Our ref: AC/2021/130461/01-L01
Your ref: TR010044
Date: 31 August 2021

A428 BLACK CAT TO CAXTON GIBBET IMPROVEMENT SCHEME THE EXAMINING AUTHORITY'S 1ST WRITTEN QUESTIONS AND REQUESTS FOR INFORMATION

Thank you for your correspondence regarding the above mentioned scheme. Our answer to your questions are provided below:

Figure 2-4: Comparison of LiDAR DTM and the Modelled Elevations Inclusive of Quarry Restoration

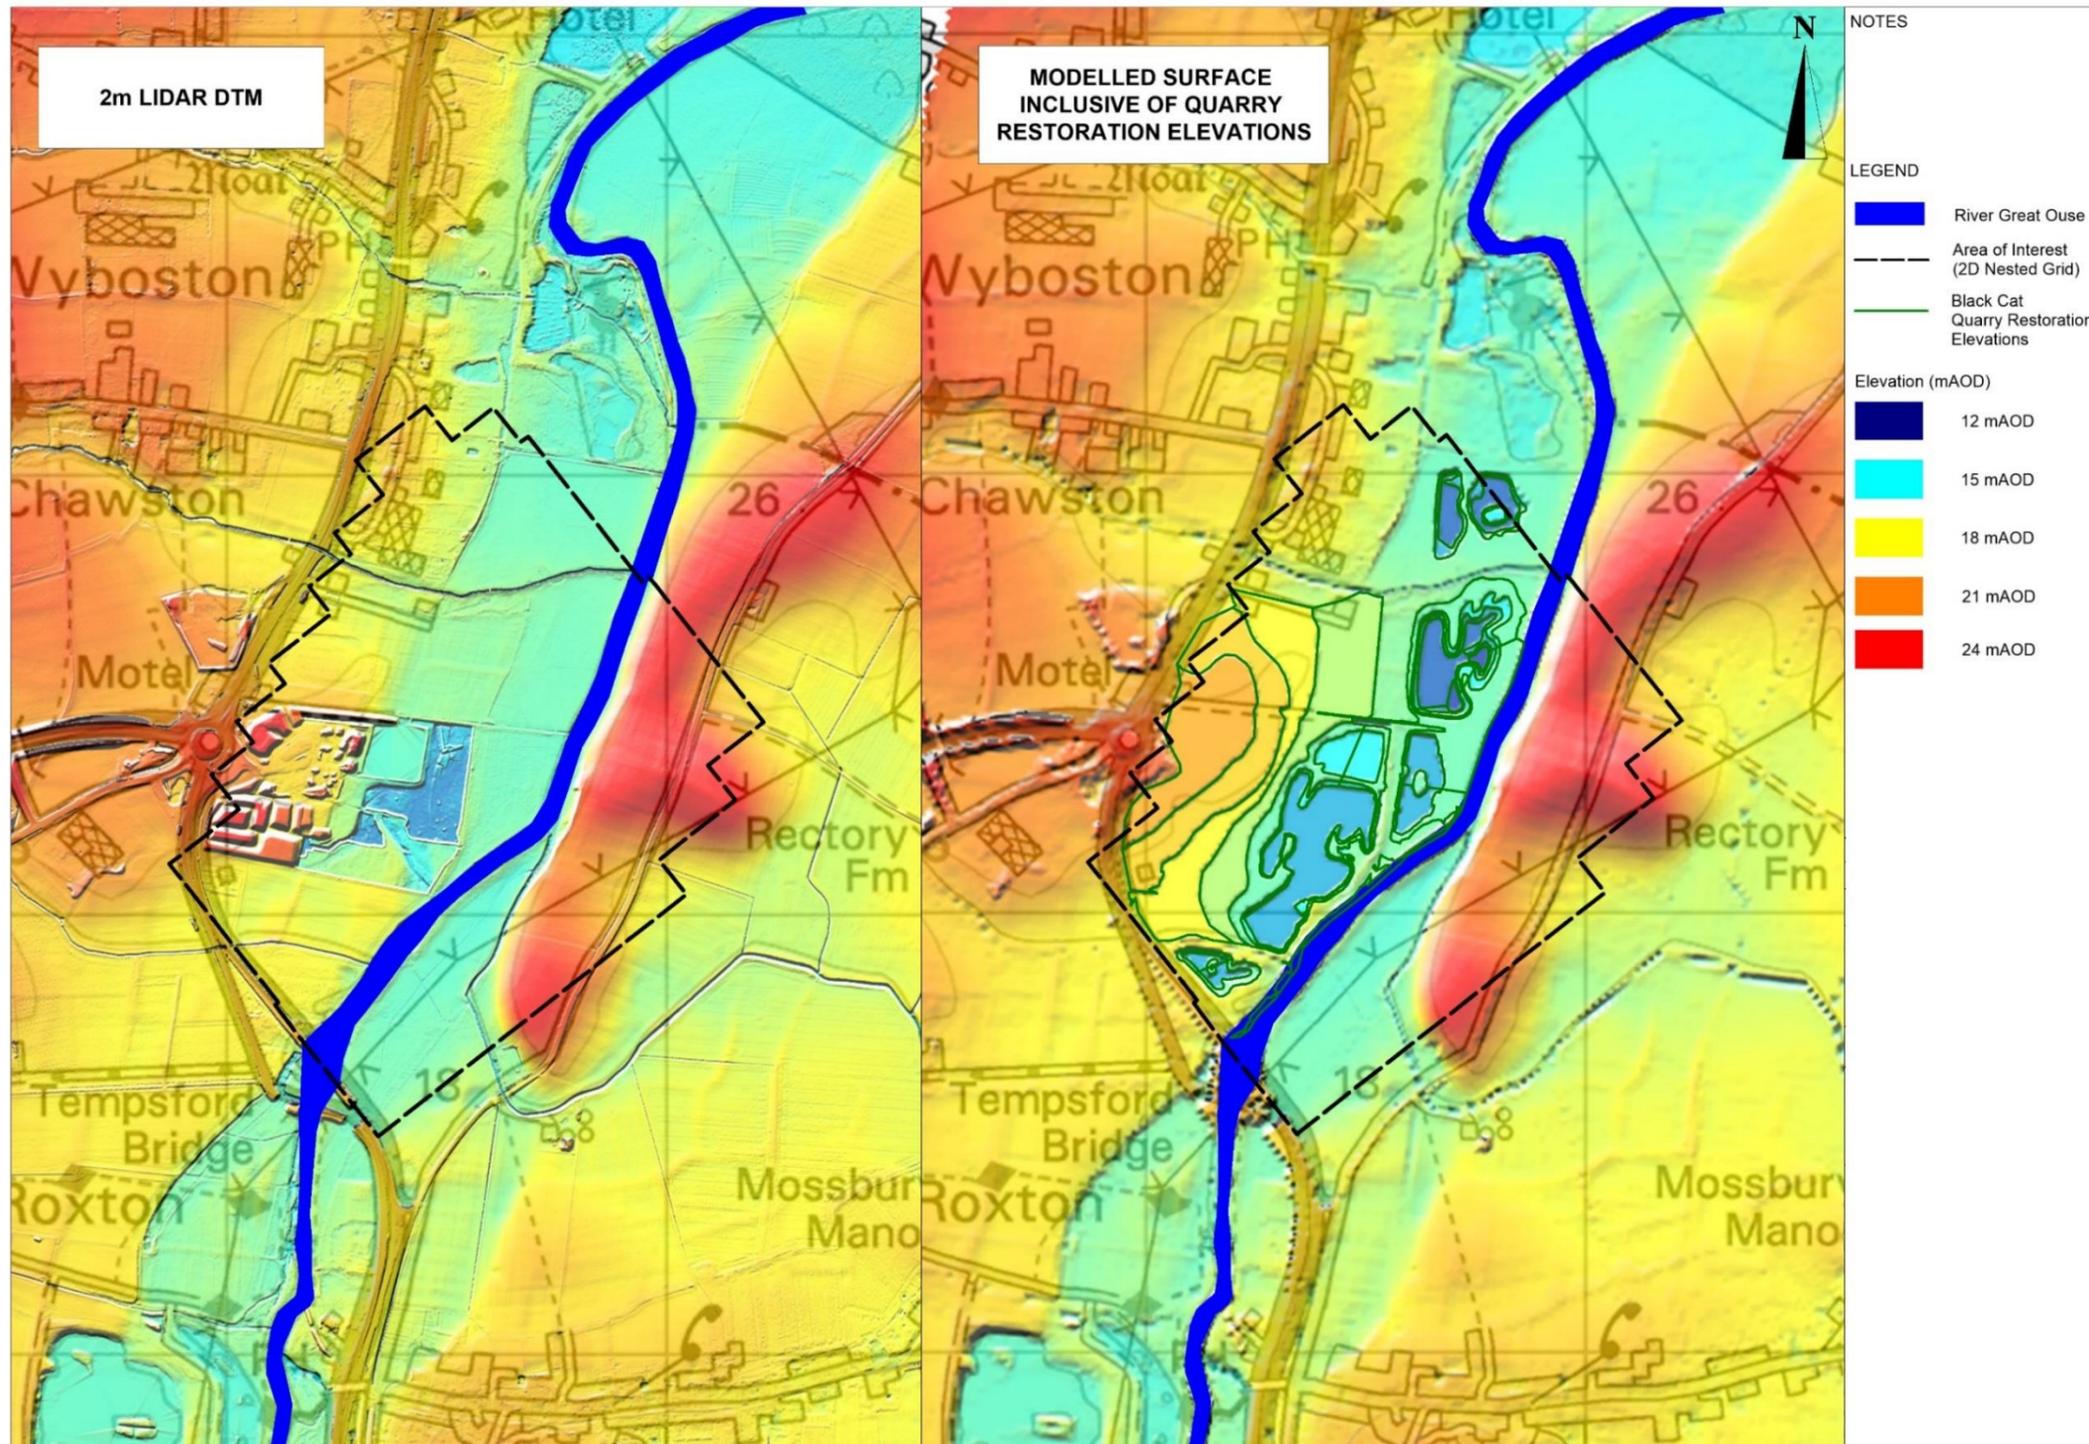
We would like to comment on this as we have concerns. The submitted FRA assumes that the Black Cat Quarry restoration works will be complete before commencement of the scheme. We understand restoration works are ongoing. However, if there is a delay to the completed quarry restoration and commencement of the road scheme starts within the floodplain then there could be implications as that scenario has not been modelled. We have an Issue on this matter within our Relevant Representation (Issue 1.7). It is paramount that either the restoration works are complete prior to commencement of the scheme or the FRA needs to be updated with the new scenarios and agreed with us prior to commencement.

c) Answer to Question Q1.9.2.2 Black Cat Quarry may assist but we have concerns over the restoration of the Quarry as this is paramount to the flood mitigation put forward as part of the scheme. Our concerns are detailed under issue 1.7 of our relevant representation. If it cannot be confirmed that the quarry restoration works will be completed prior to the commencement of works, we will need to see evidence that the proposed floodplain compensation area will function as detailed in the FRA.

Figure 2-8: River Great Ouse Proposed Permanent and Proposed Permanent Plus Temporary Works Design

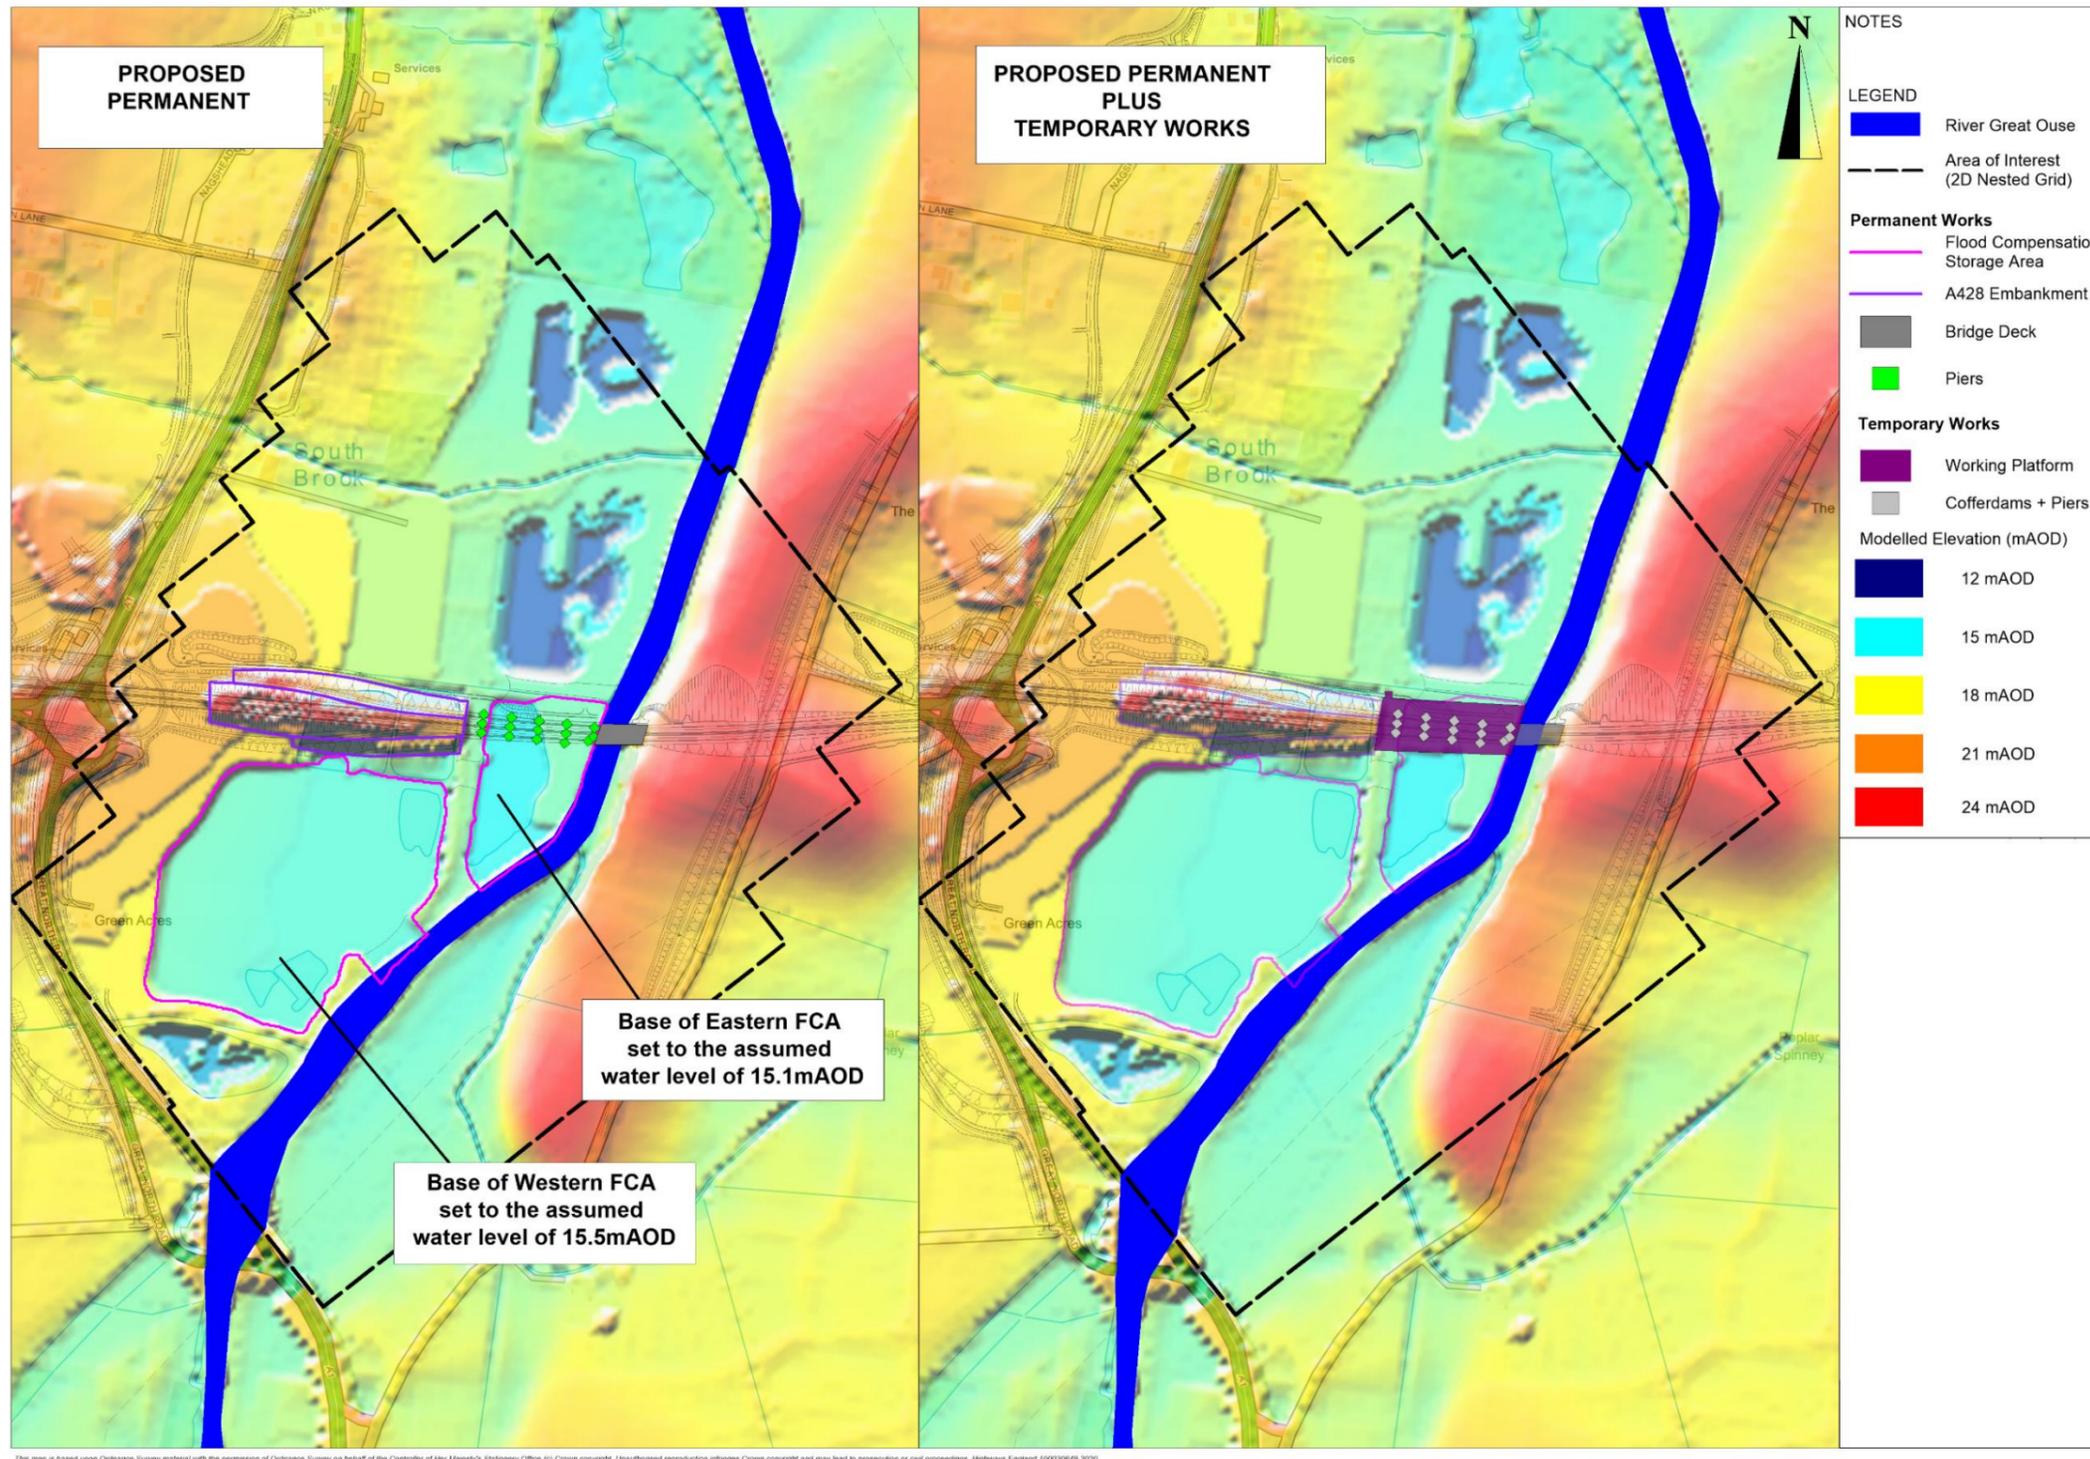
With regard to the River Great Ouse crossing design, four options were presented to us, which are detailed in Annex A of the FRA. The preferred option was the one resulting in the smallest increase flood levels so was considered to be the best option in terms of flood risk. We were informed that other options were also considered but these all showed greater increases in flood risk. Although we asked to see details of these other options, this information was not provided to us. This information would have been useful for us to see whether there were any further net gain opportunities when crossing the River Great Ouse and its floodplain.
